RE: ENGINEERING CONSTRUCTORS (L19-D56). ENGINEER'S CERTIFICATION FOR CERTIFICATE OF OCCUPANCY. ENGINEER'S CERTIFICATION DATED JULY 1, 1997.

PROJECT TITLE: Engineering Constructors ZONE ATLAS/DRNG. FILE #: L19-D56

**RE: ENGINEERING CONSTRUCTORS (L19-D56). GRADING AND DRAINAGE PLAN
SUBMITTAL FOR BUILDING PERMIT APPROVAL. ENGINEER'S STAMP DATED
FEBRUARY 19, 1997.**

# DRAINAGE FACILITIES WITHIN CITY RIGHT-OF-WAY

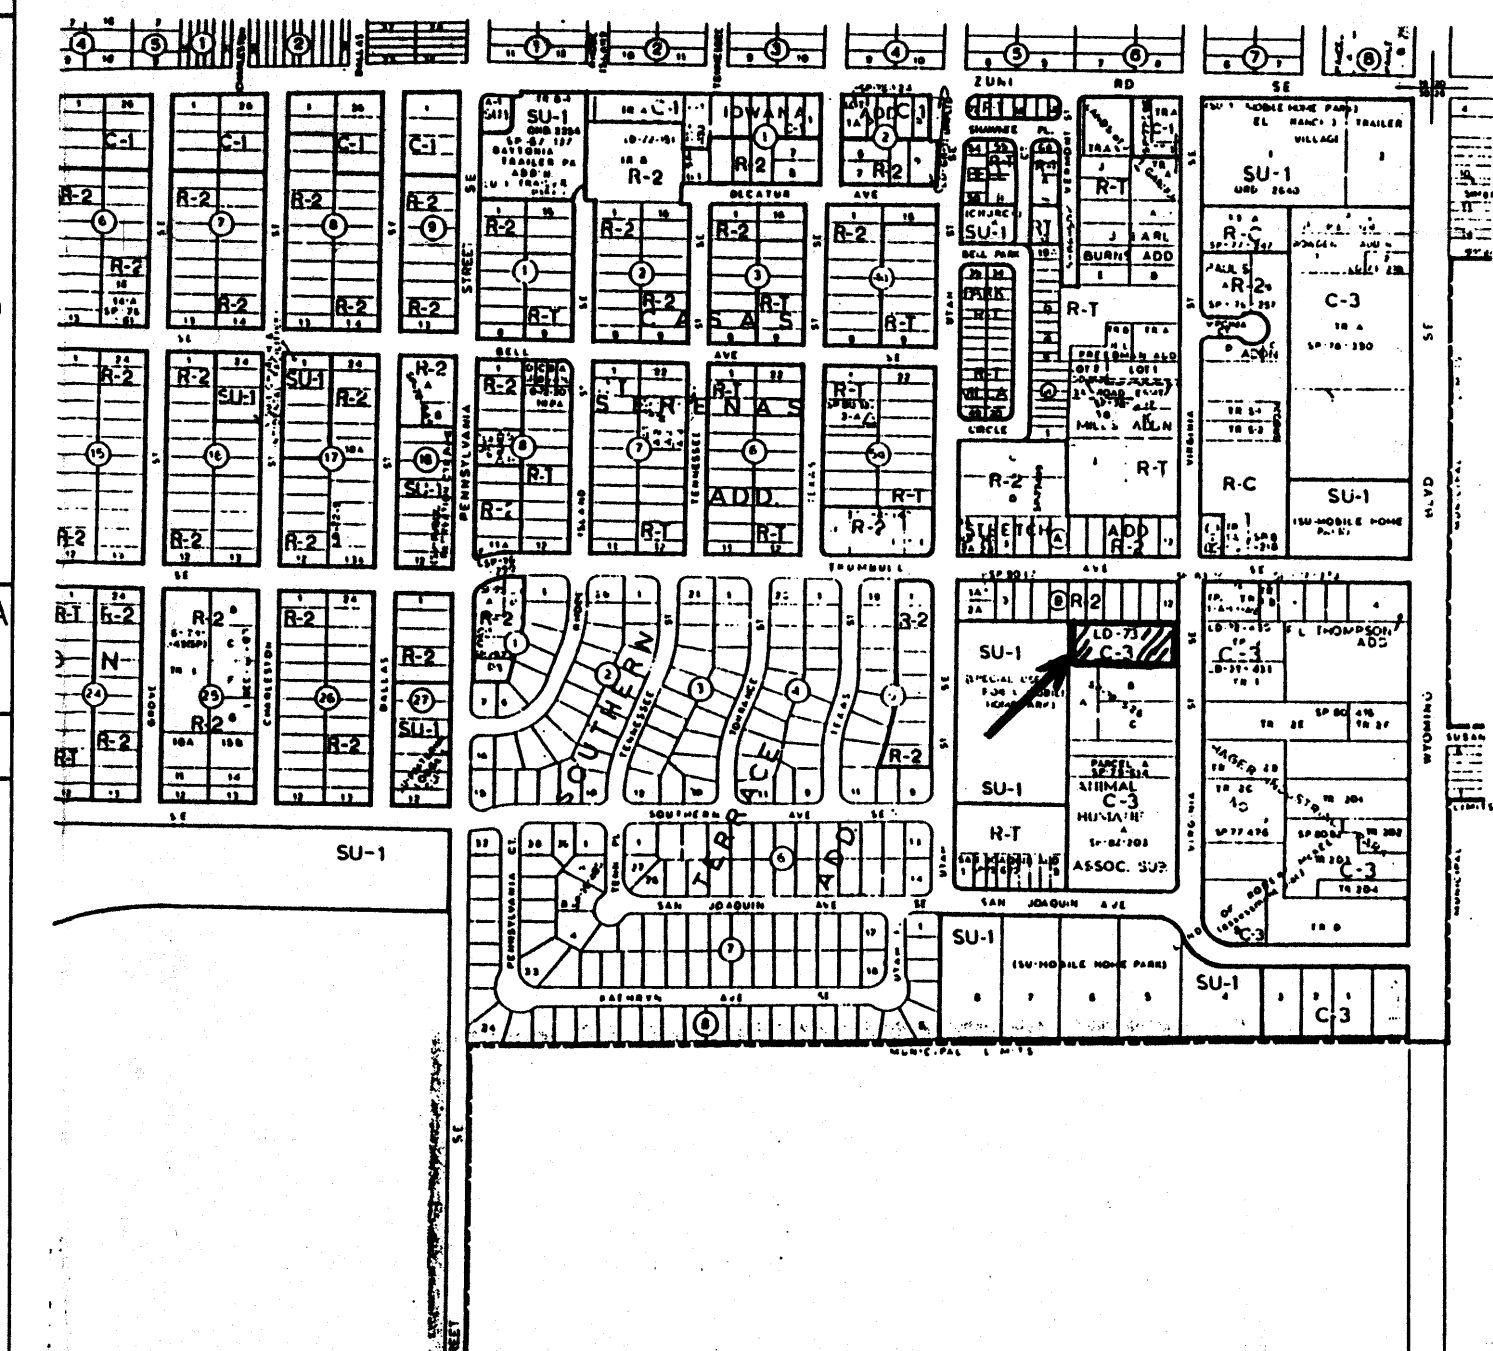
1. Show some existing street grades in Virginia. A 1-foot water block is required at the drive way.
2. Provide the invert elevations (in and out) of the sidewalk culvert (trench drain).
3. An SO #19 Permit is required for the sidewalk culvert.

SHEET TITLE  
**DRAINAGE AND GRADING PLAN**

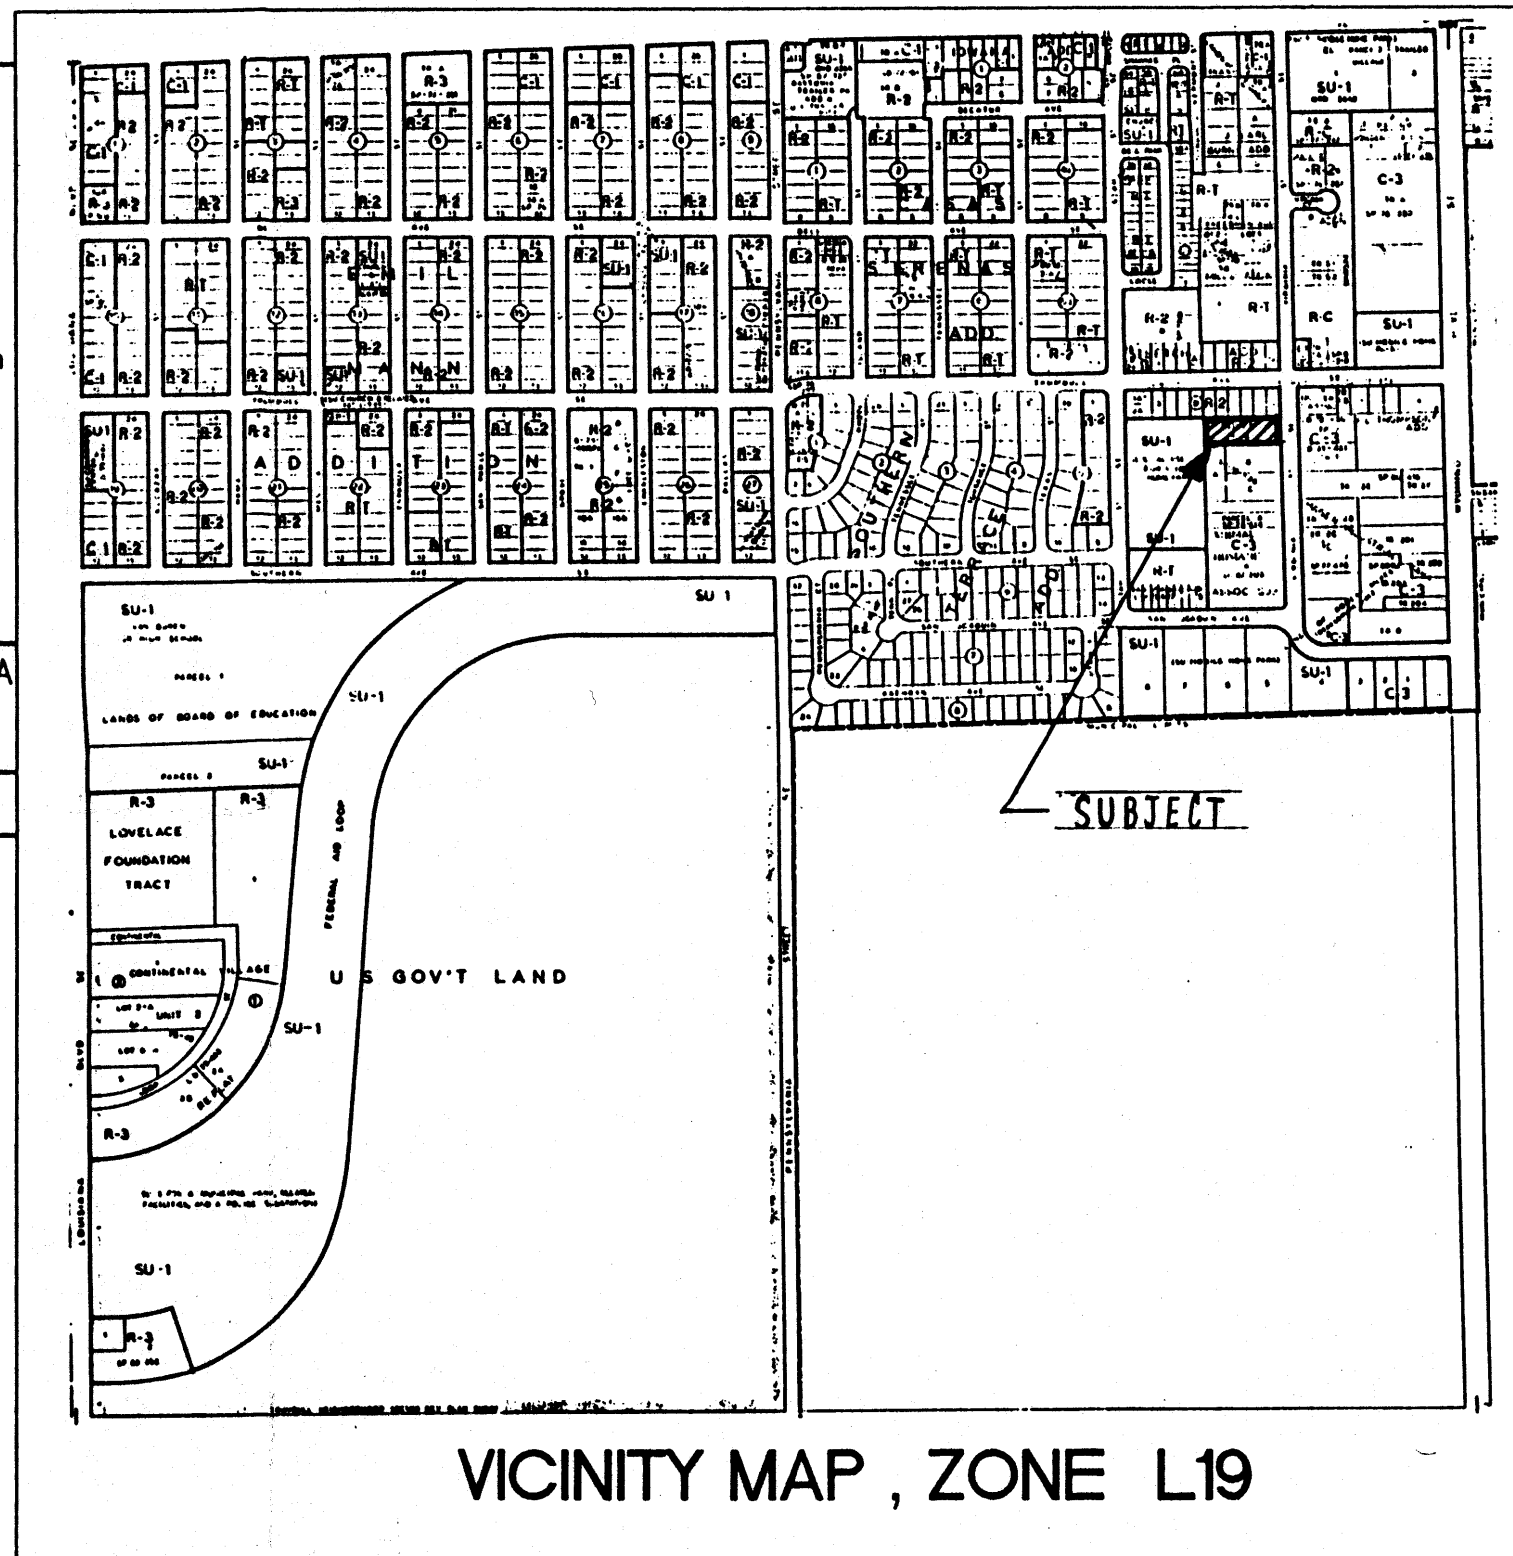
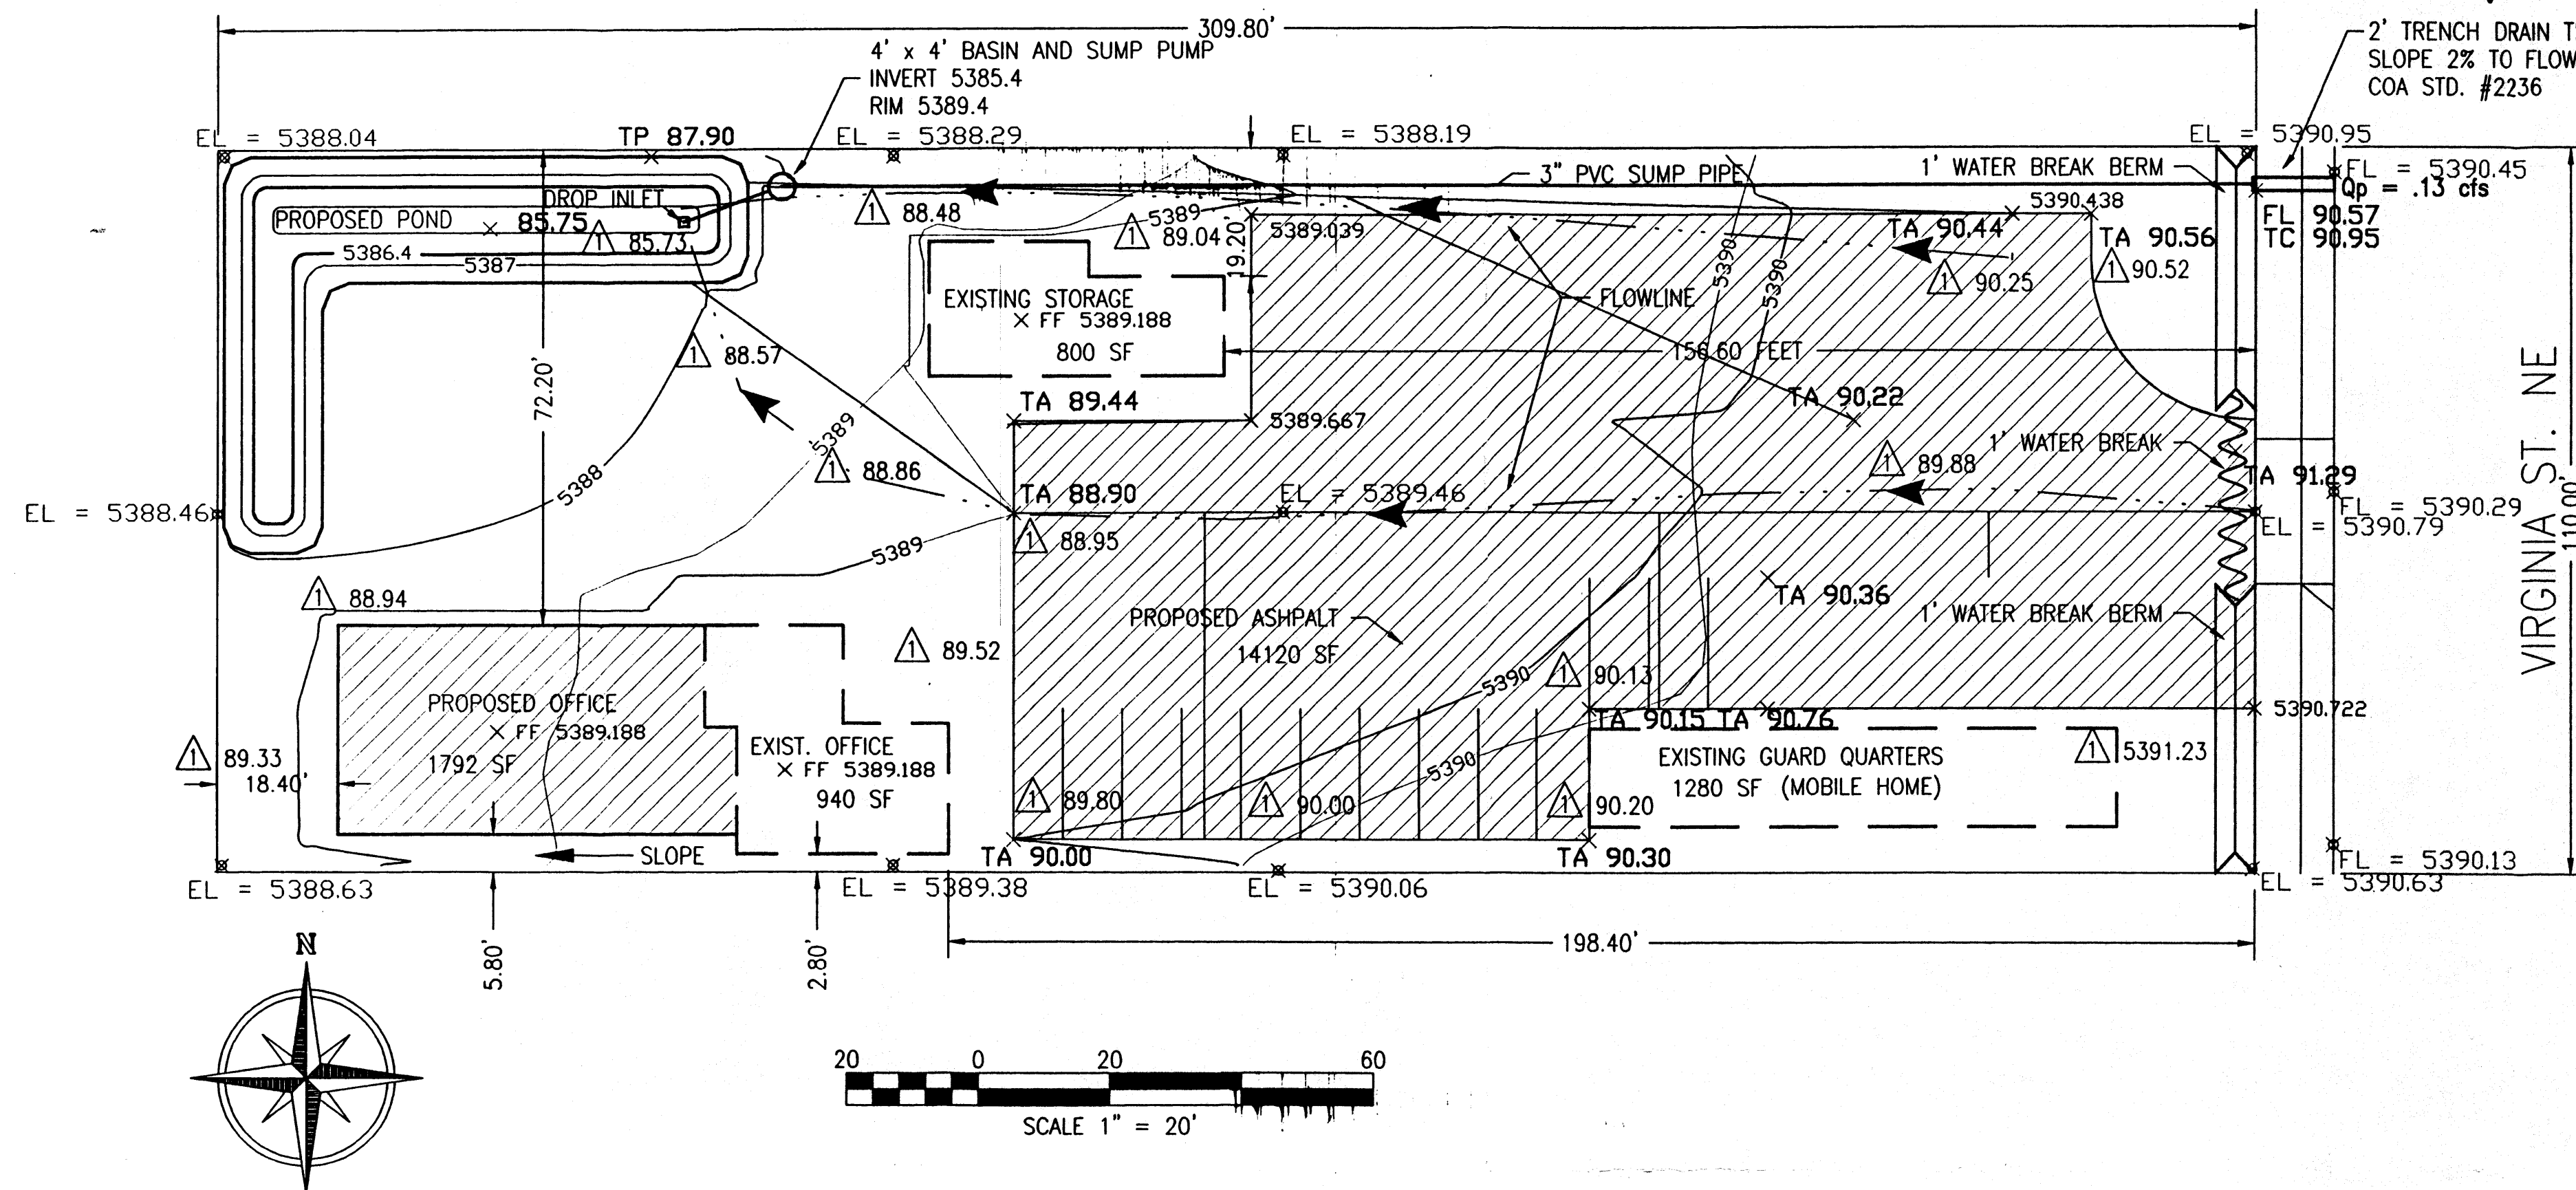
1. Submit a copy of the City Inspector's "green tag" for the
sidewalk culvert.
2. Provide your NMPE number on Certification statement.
